Date: 28-Jan-2025
Our Ref: 2024/93332

**Application for a non-material amendment following a grant of planning permission,
Town and Country Planning Act 1990**

**Non material amendment to previous permission 2024/91186 for variation of conditions 2 (plans and specifications), 14 (Landscape Plan) on previous permission 2022/92718 for demolition of fire training building, extension and landscaping of RTC yard, including erection of fuel pump and tank, bin store and dog kennels, recladding of the BA building and erection of an enclosed link between BA and TRTC, provision of a new sub-station and new boundary treatments, retaining and landscaping works
Oakroyd Hall, West Yorkshire Fire And Rescue Service Headquarters, Bradford Road, Birkenshaw, BD11 2DY
Application Number: 2024/93332**

**Proposed Roof GA Floor Plan**

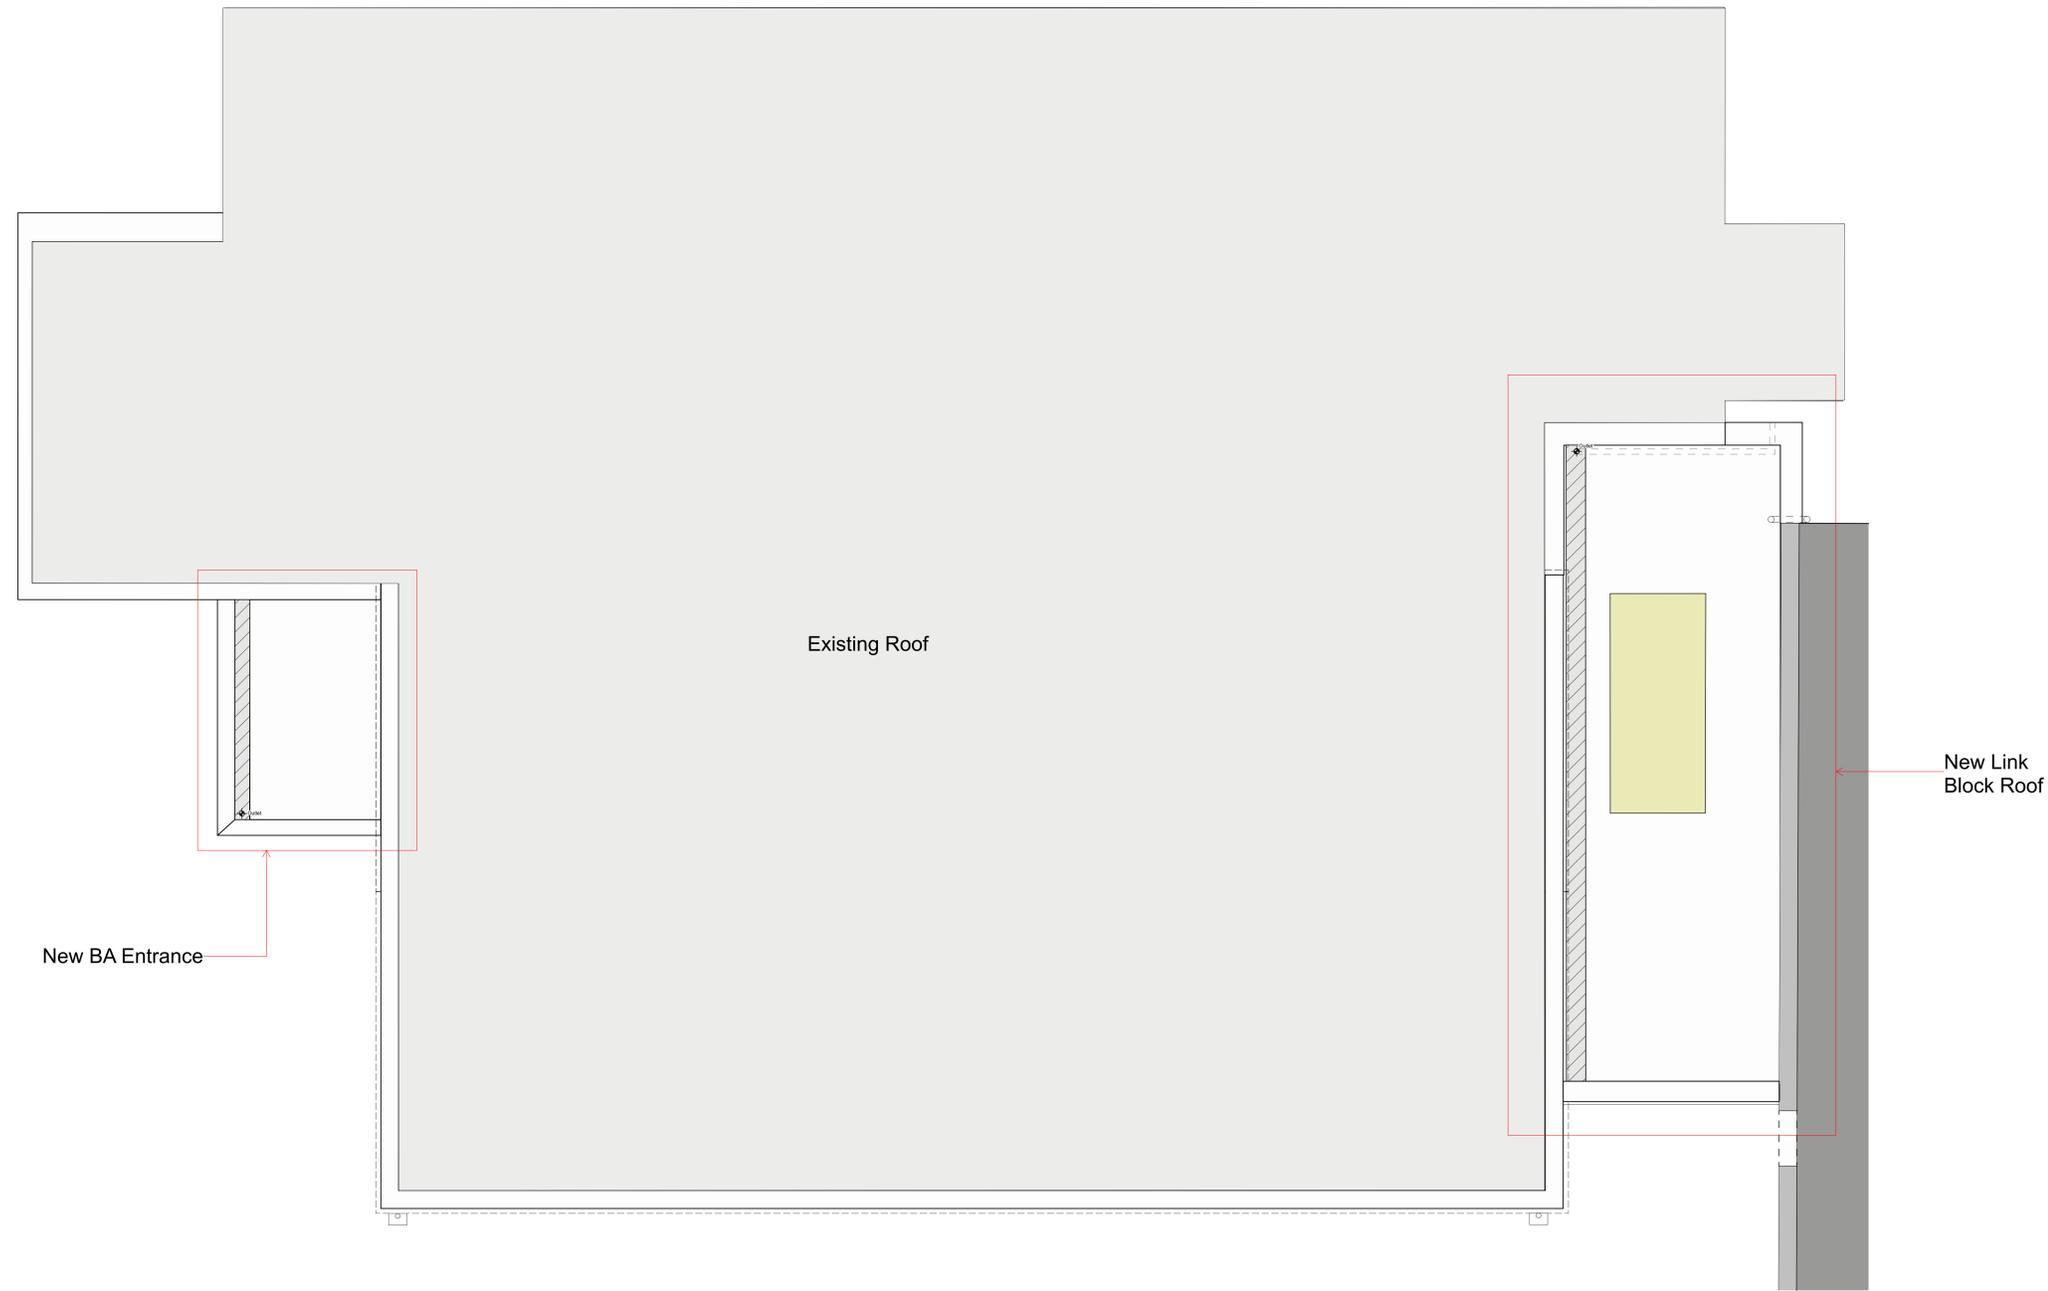
- i. A new BA link block between the BA building and Technical Training Centre (TRTC) building, in place of a canopy as approved.
- ii. Louvres introduced to the west side of the BA link as well as a door.
- iii. 2no. AC units relocated to the BA link roof.
- iv. New guarding installed on the BA link roof.
- v. The BA entrance to the north side of BA demolished and a new entrance will be built.
- vi. Cladding installed to the west elevation of the BA building over the existing high-level windows.
- vii. 5no. new doors on the BA elevations.
- viii. The rainwater downpipes on the west elevation of the BA building will be replaced.
- ix. A new steel frame canopy is proposed to be installed at the rear (east) of the TRTC building to cover the outside seating area and 2no. new steel frame canopies outside the main entrance doors to the BA and TRTC buildings.
